CITY OF MERCER ISLAND

RE: Review Comments for File No. CAO19-014 – Headrick Garage and Pool Addition
8822 SE 26th St, Mercer Island, WA 98040; King County Tax Parcel # 865050-0040

BUFFER RESTORATION PLANTING PLAN

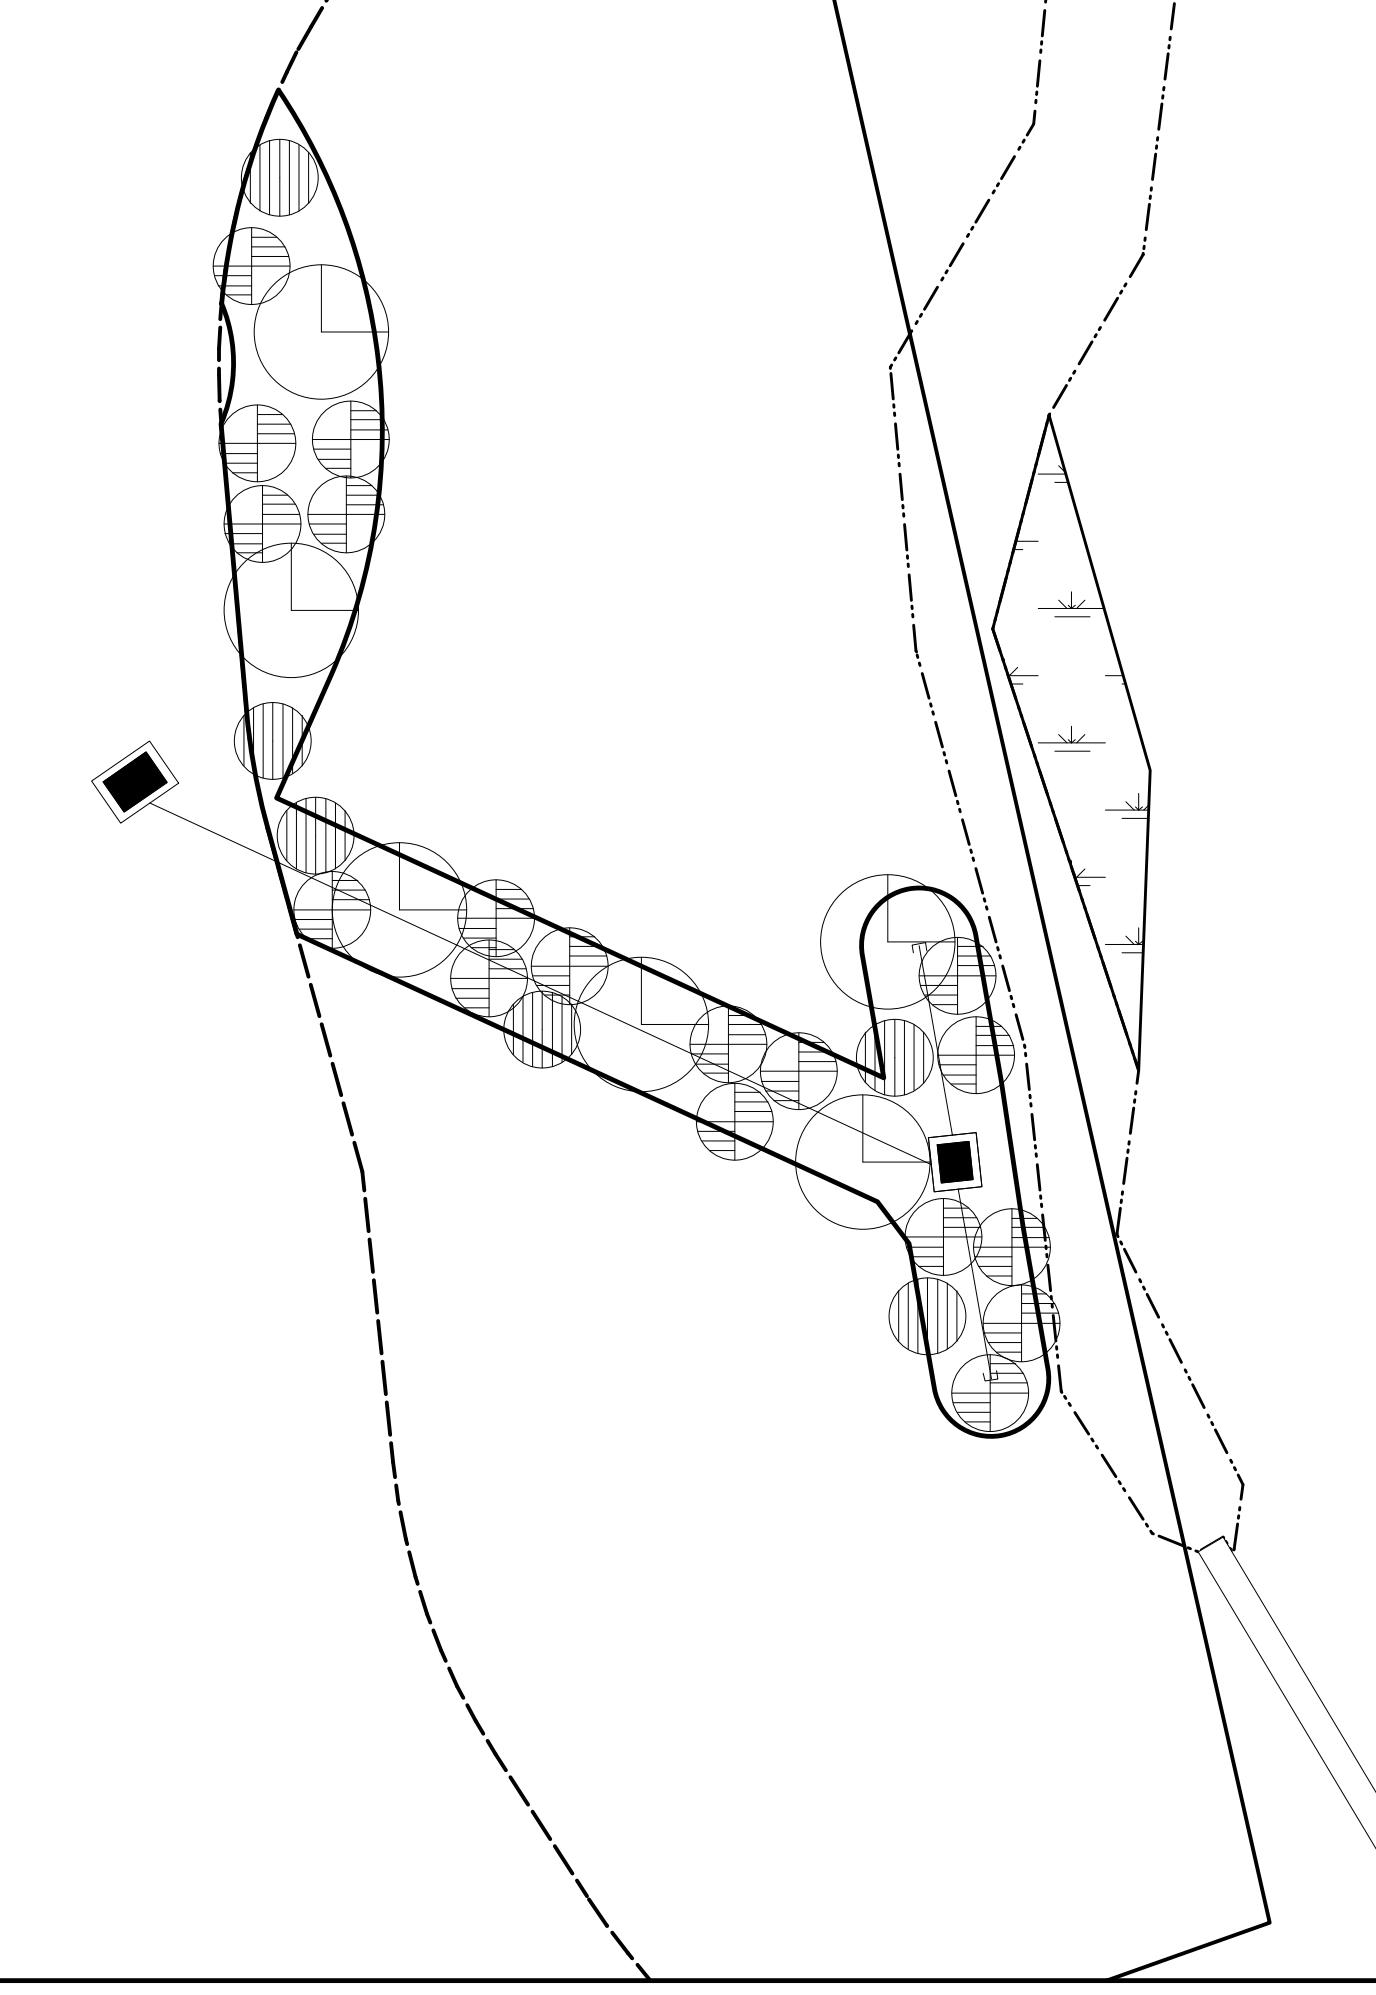
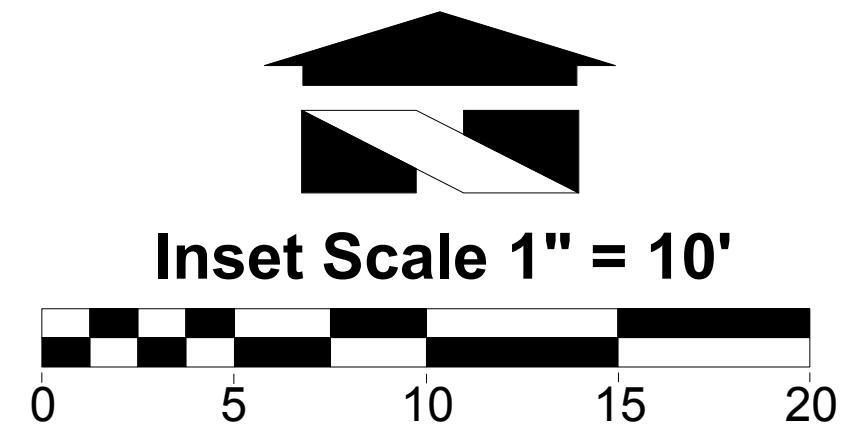
3. According to Performance Standard 1b1 of the Buffer Restoration Plan, installed and native volunteer species shall achieve 50 percent aerial cover by Year 5. Please increase aerial cover to 70 percent as 50 percent aerial cover is a low requirement for Year 5 aerial cover performance standards. To help achieve 70 percent aerial cover by Year 5, the following is recommended based on the proposed plantings and quantities: increase the density of proposed plantings (e.g. use 4-foot spacing for shrubs and 2-foot spacing for groundcovers); and/or install additional salmonberry plantings rather than strawberry groundcover plantings.
